Planning Act 2008 – Section 88 and the Infrastructure Planning (Examination Procedure) Rules 2010 – Deadline 8: Post Hearing submission of oral case for Issue Specific Hearing 11 (Flooding, Water and Coastal Processes).

Application by NNB Generation Company (SZC) Limited for an Order Granting Development Consent for the Sizewell C Project

Appendix A: Environment Agency summary of oral case for ISH11: Flooding, Water and Coastal Processes

**TR544: PRELIMINARY SCDF DESIGN**

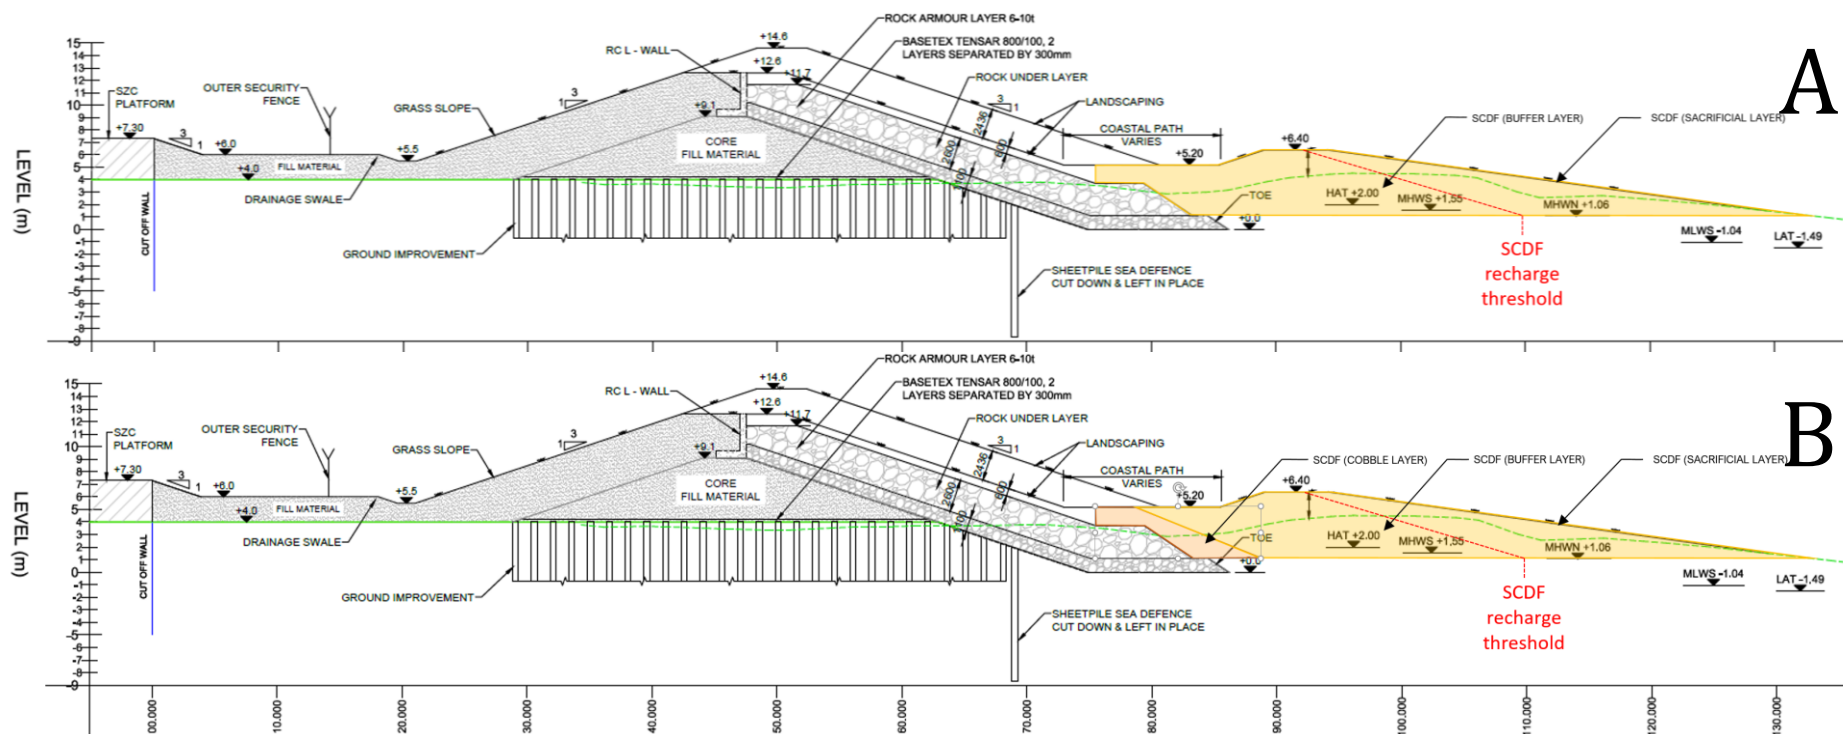
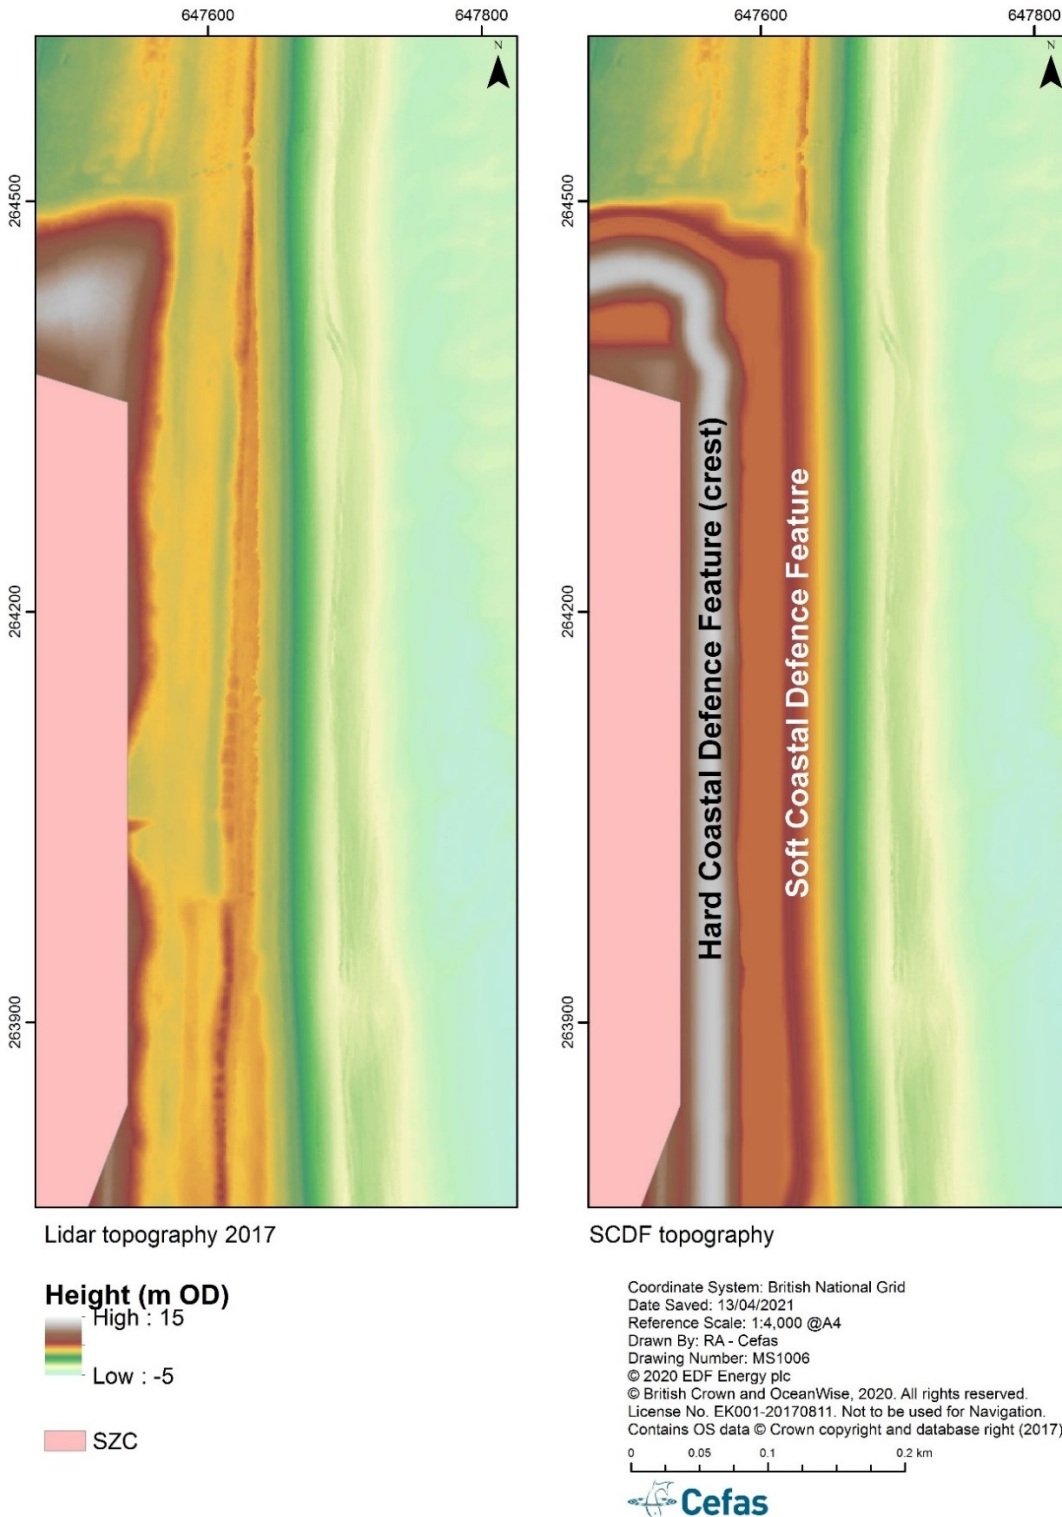
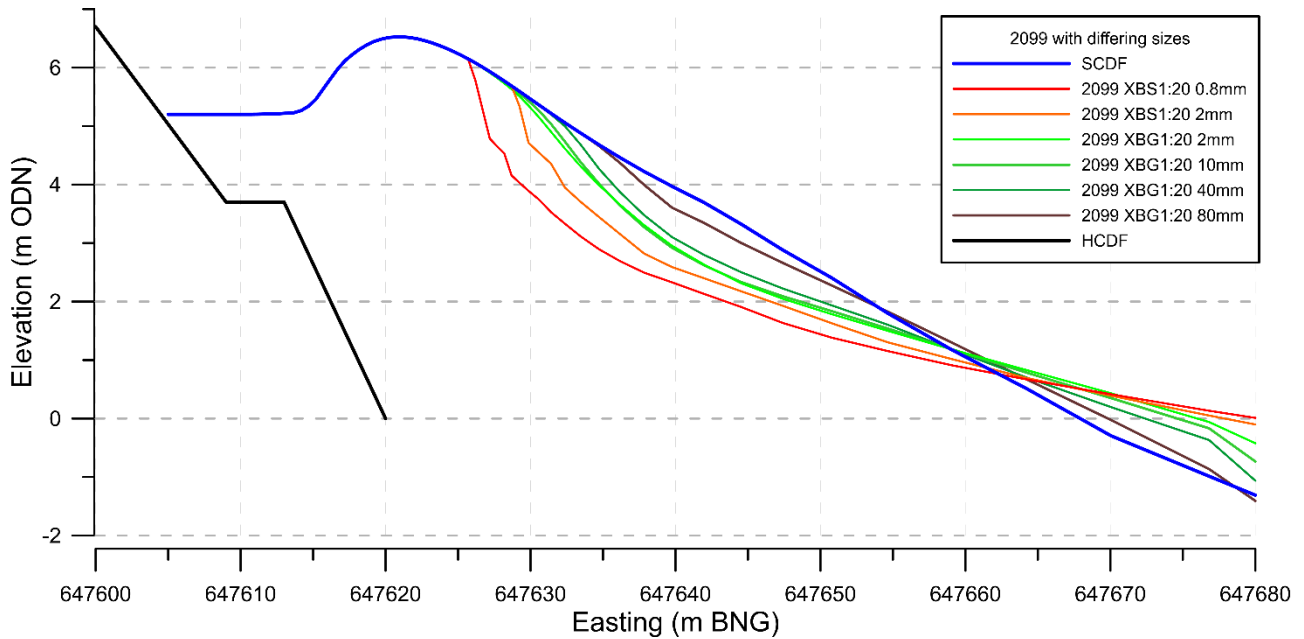
<p>modelling relating to the detailed design of the adapted HCDF;</p>	<p>As with our previous response, we must add the caveat to this response that our detailed review remains ongoing, and so at this time we can only share broad headline messages based on an early light touch review.</p> <p>We are pleased to see the inclusion of the updated HCDF design, including pairing back of the crest at the northern end and a seaward deviation at the southern end. We note that further work is planned to model this design during the operational phase, though this version of the design report does suggest that this is considered unlikely to alter the existing conclusions.</p> <p>It is notable that the modelling of the adapted design and RCP8.5 sea level with the NE 1 in 20 yr return period wave climate results in erosion locally exceeding the sacrificial layer volume, meaning immediate recharge would be required to avoid HCDF exposure in the event that another moderate storm were to occur soon after. The report notes that this is an 'unlikely worst case scenario' but we feel this will require further examination in the next iteration of the modelling and design reports (particularly when considering more severe wave conditions and possibility of storm clustering as a reasonable worst case).</p>

<p>A coarse cobble layer buried beneath the main SCDF and sitting atop the HCDF is suggested as mitigation for this risk. We recognise the logic behind this suggestion, and look forward to reviewing the modelling of this scenario in version 4. We particularly welcome suggestions such as this which would in theory avoid coarsening of the main SCDF particle size towards the upper end of or beyond the natural size range for the Sizewell frontage, given the environmental impacts that could result from such a modification away from native conditions. However, this would be provisional on a high degree of comfort that the cobble layer would remain buried, since regular or prolonged exposure could alter the morphodynamics and detrimentally affect the environment.</p>
the SCDF design;	<p>At the hearing we highlighted we remain fairly comfortable with the SCDF design, with the caveat again that work is ongoing to complete the necessary assessments which will ultimately determine the final design options.</p>
